DESCRIPTION OF REQUEST: FINAL SIGN-OFF OF AN EPC APPROVED SITE PLAN FOR BUILDING PERMIT

OFFICIAL NOTIFICATION OF DECISION

October 14, 2016

**Project# 1002717
16EPC-40045 Site Development Plan for Building Permit**

3 NORTH ELEVATION SCALE: 1/16"=1'-0"

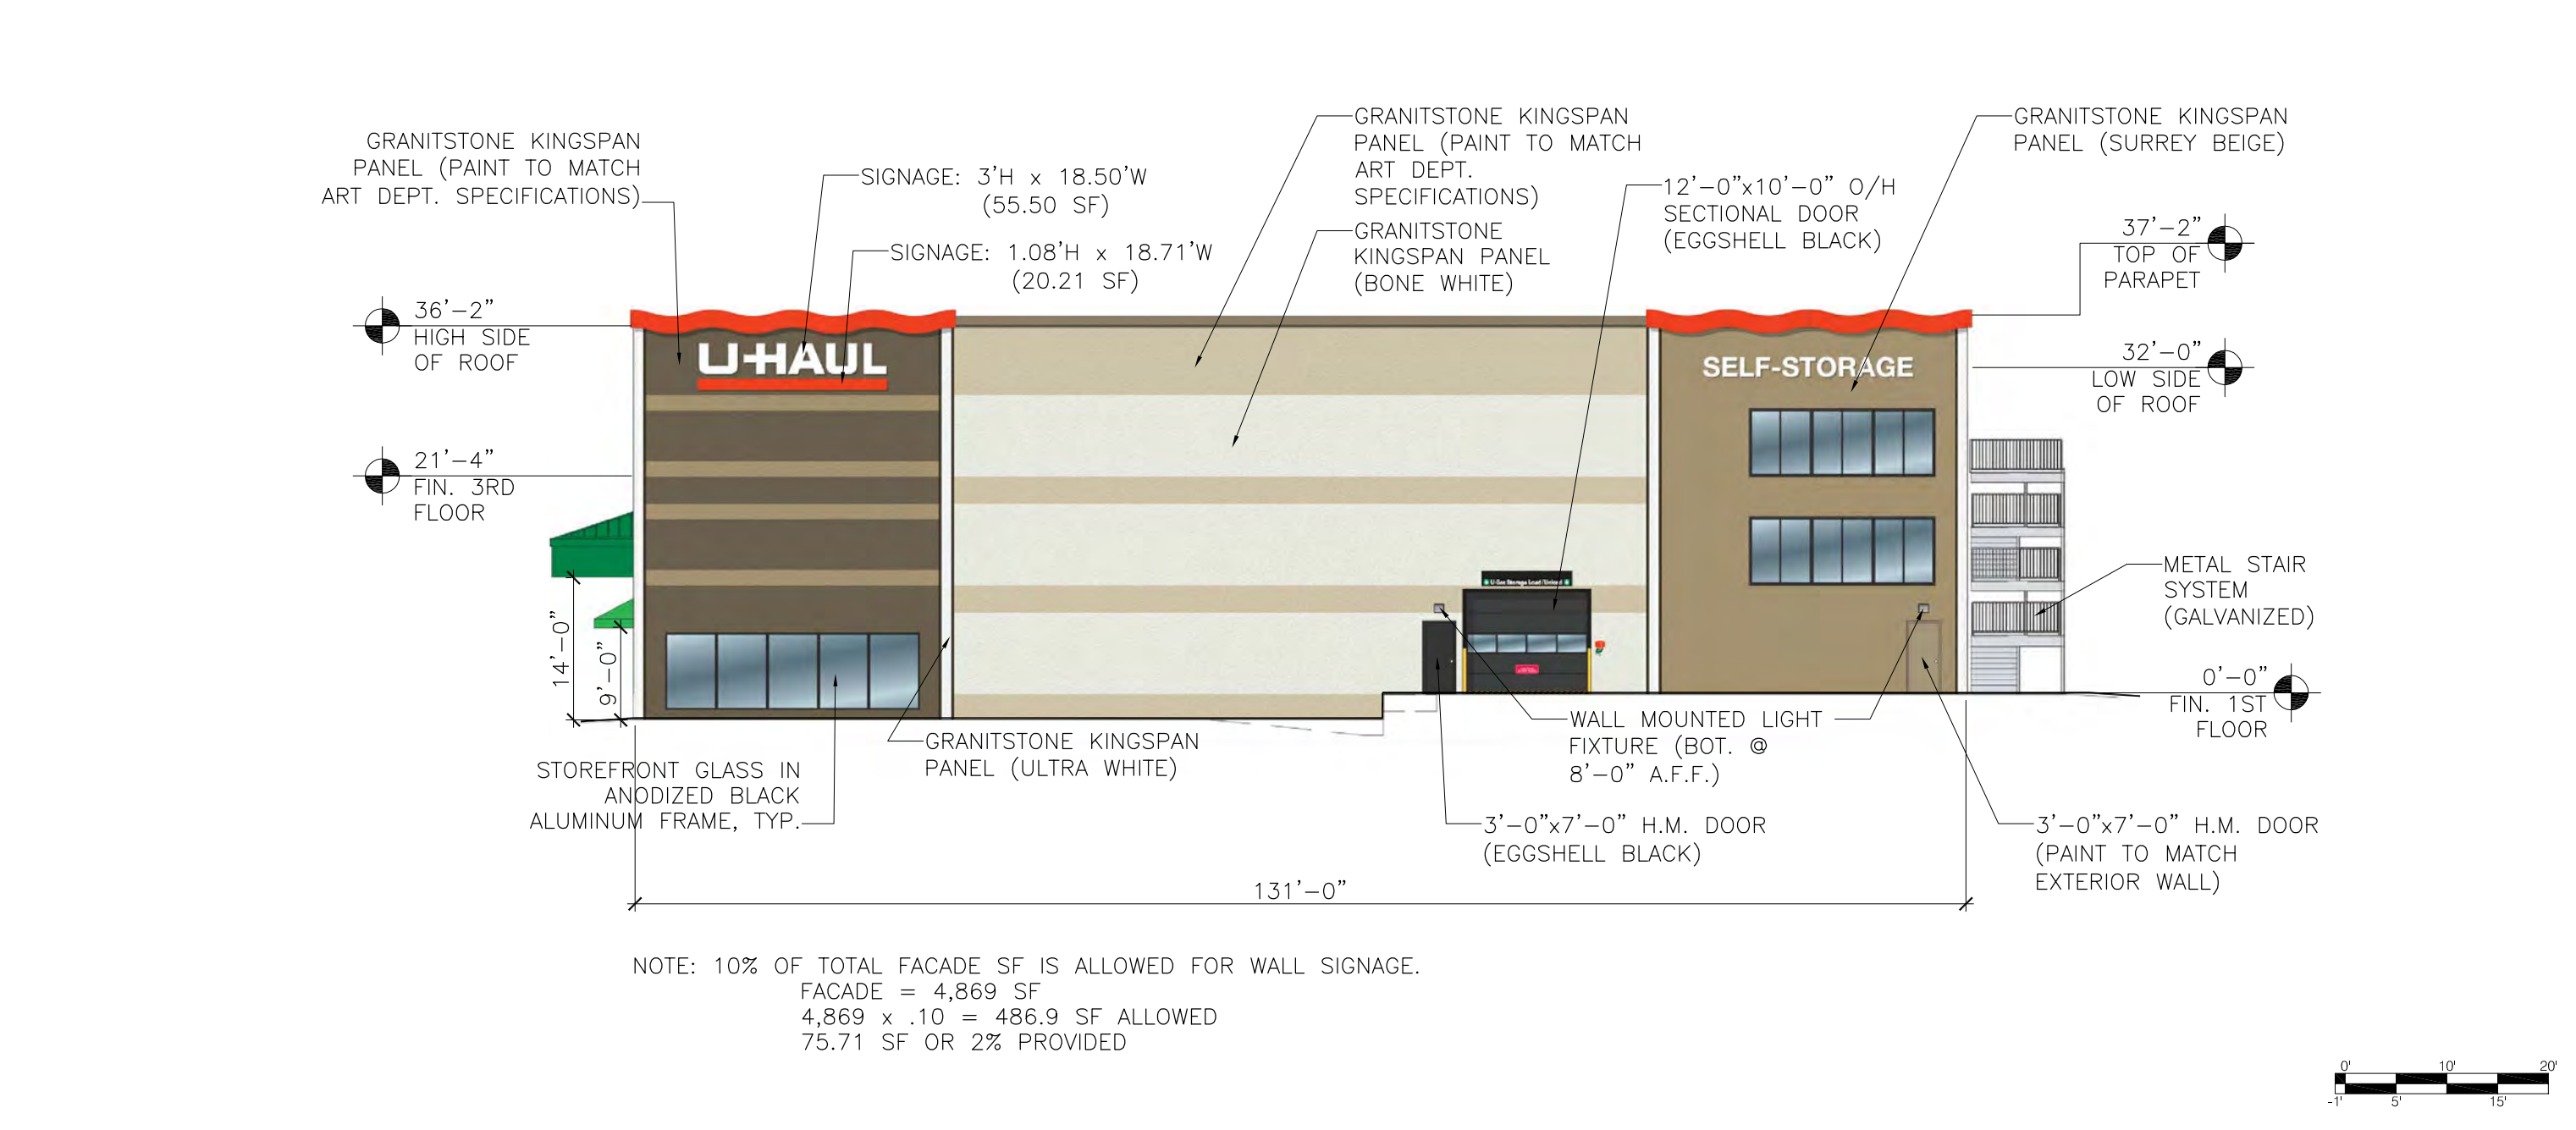
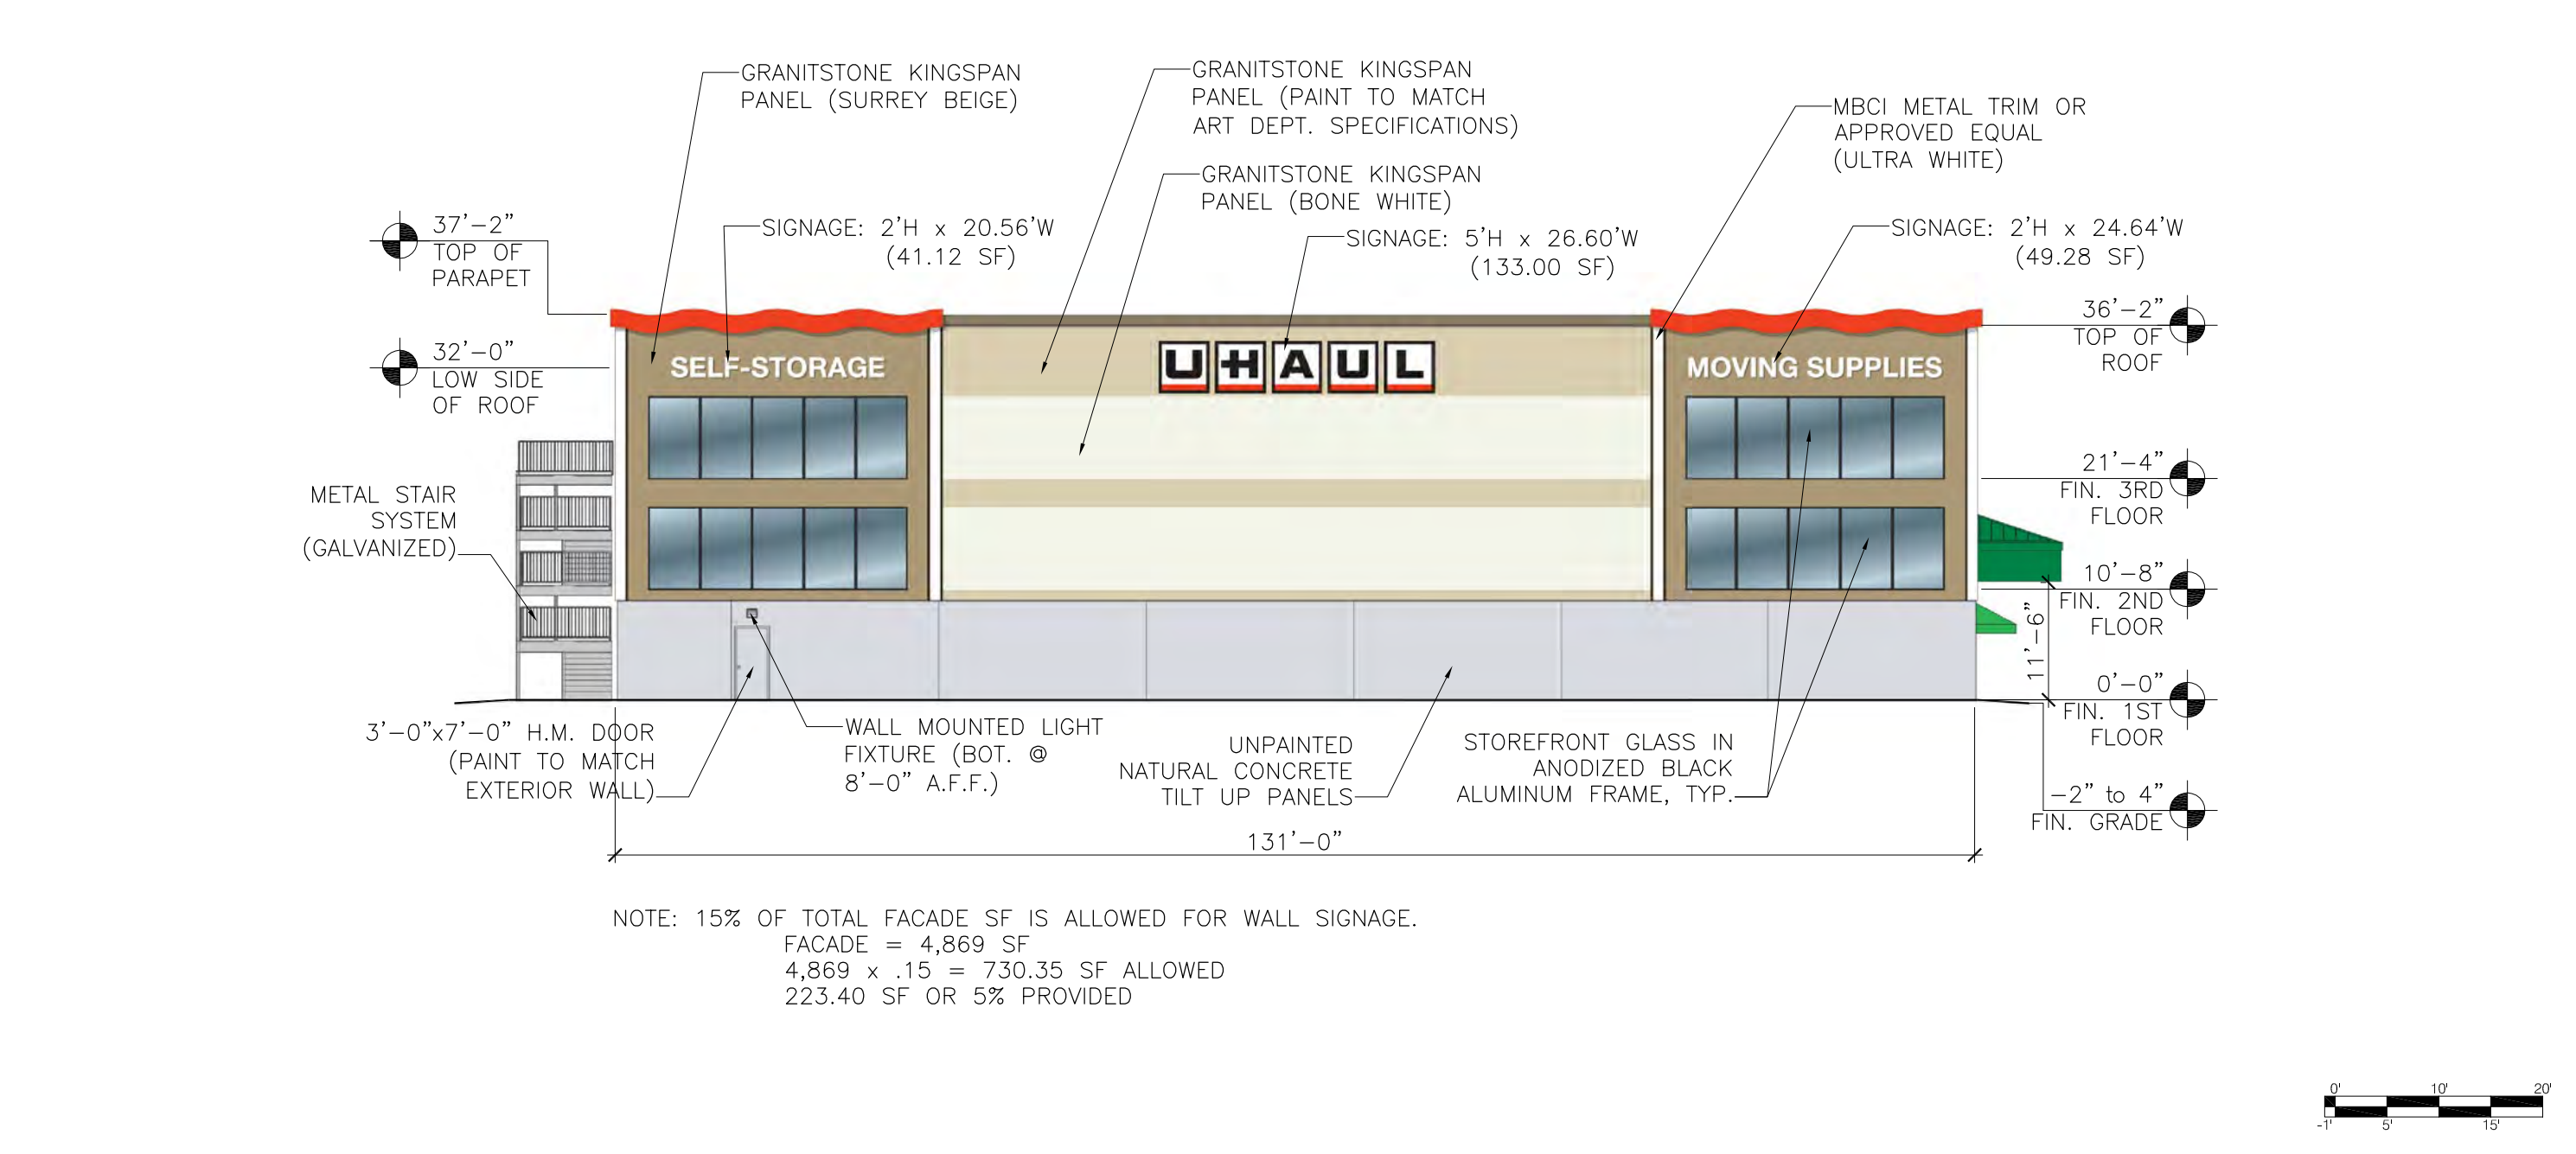
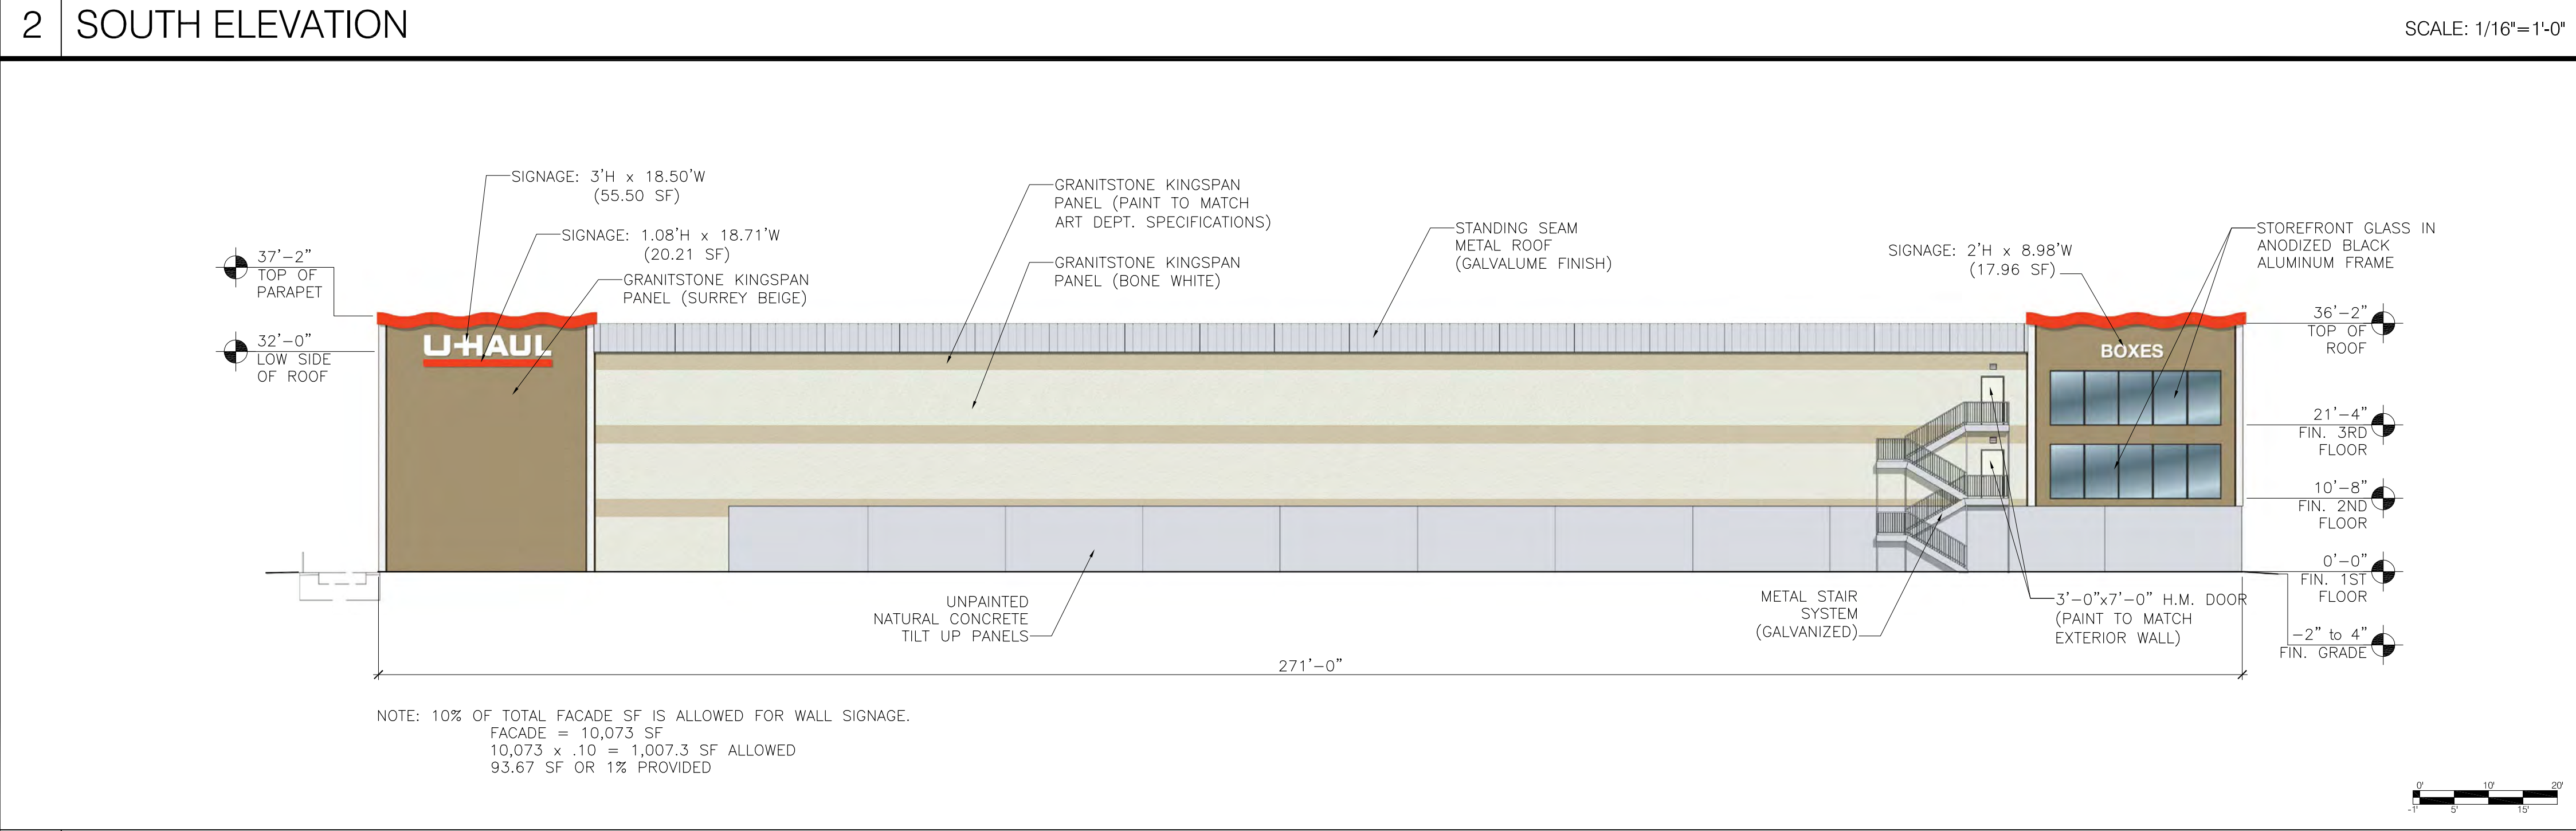
6. The applicant shall add a stucco finish to all proposed MCBI metal wall panels along each of the building elevations shown on Sheets A2 and A3, in order to better integrate the development with the surrounding development and address neighborhood resident comments as outlined in the facilitated meeting report (see attached).

9. The applicant shall amend the building mounted signage diagrams on Sheet A2 to meet the requirements of the C-2 zone Section 14-16-2-17(A)(10)(d)(2) which states that building mounted signage height shall not exceed 30 feet, or seek a signage variance through the Zoning Hearing Examiner (ZHE) concurrent with submitting an application to DRB for final sign-off.

10. The applicant shall amend the notation section under each building façade diagram on Sheet A2 to correspond to the appropriate building mounted signage square footage listed under Section 14-16-2-17(A)(c)(2)(i – iii) as noted below:

- a. Northern façade: Maximum allowed = 10%
 - b. Southern façade: Maximum allowed = 15%
 - c. Eastern façade: Maximum allowed = 10%
 - d. Western façade: Maximum allowed = 15%
